Submission Summary - Government Agencies

Kembla Grange Resource Recovery Facility (SSD-5300)
50 Wyllie Road, Kembla Grange

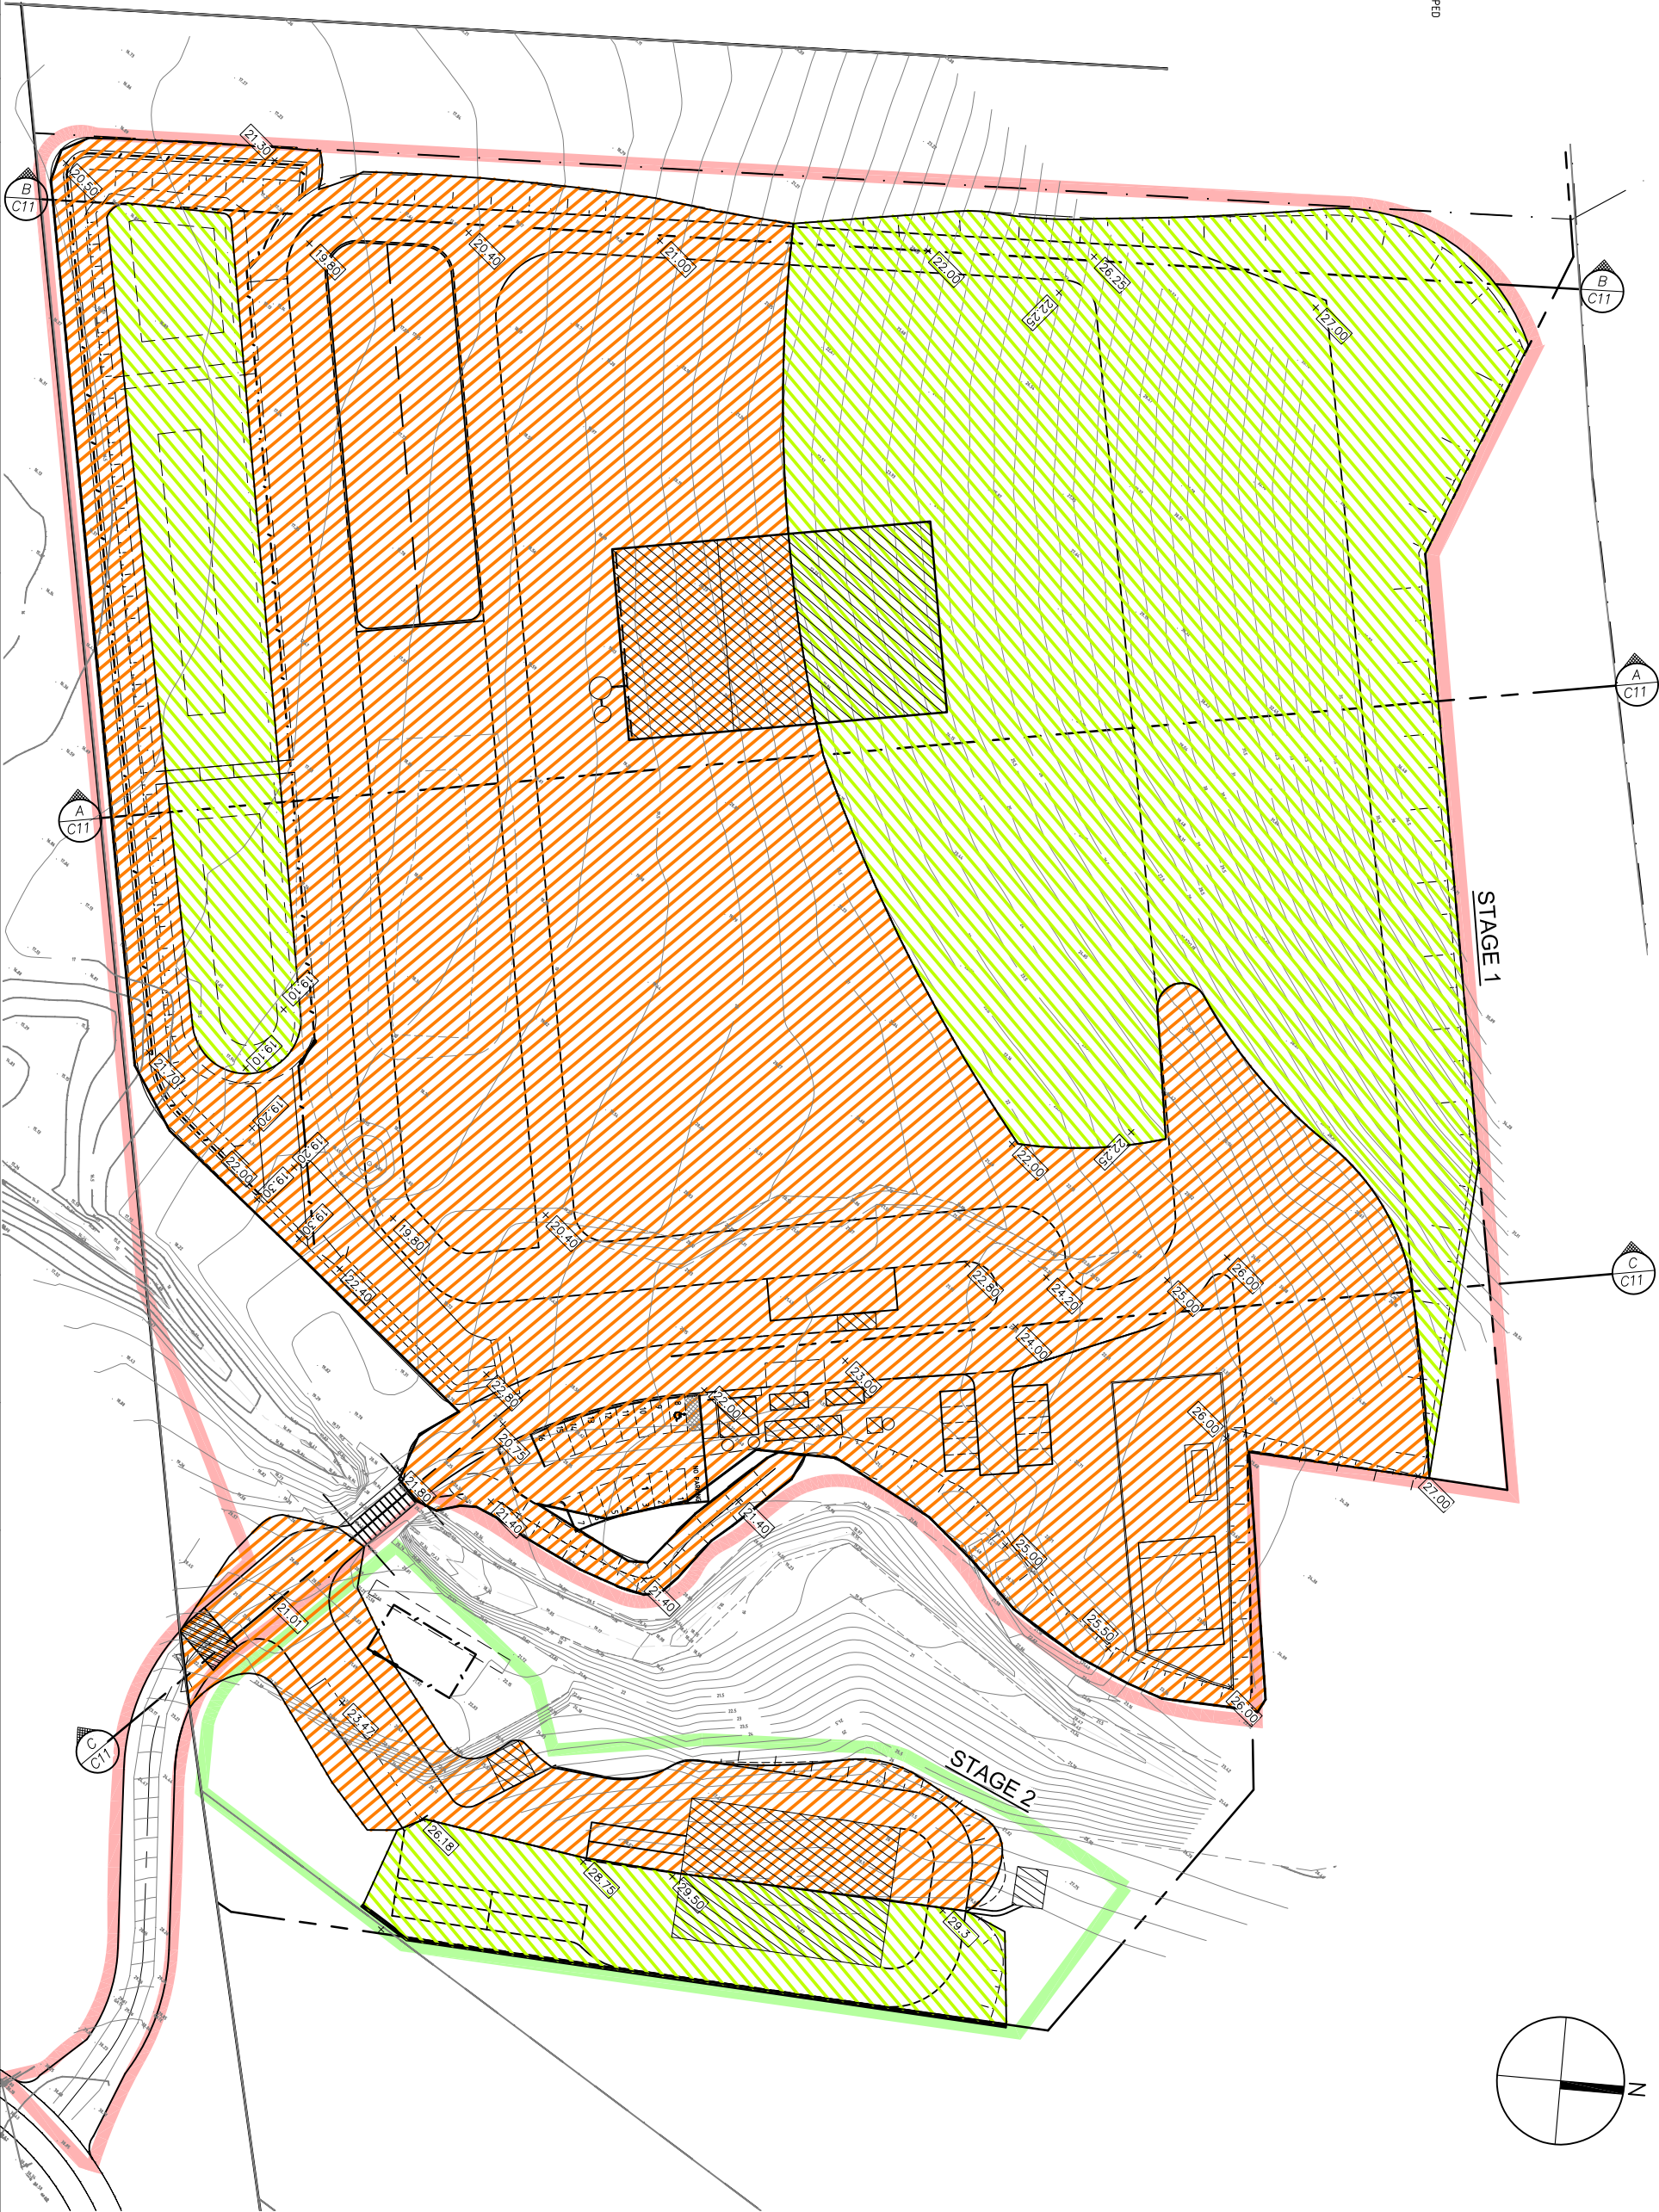
Water The DPE have raised the following issues related to stockpiling: <ul style="list-style-type: none"> • Provide details of temporary vegetation to stockpile areas where stockpile is to be left for more than two months, as indicated on the Soil and Water Management Plan. • The legend to Dwg C28 Cut and Fill Plan does not distinguish between areas of cut and areas of fill.
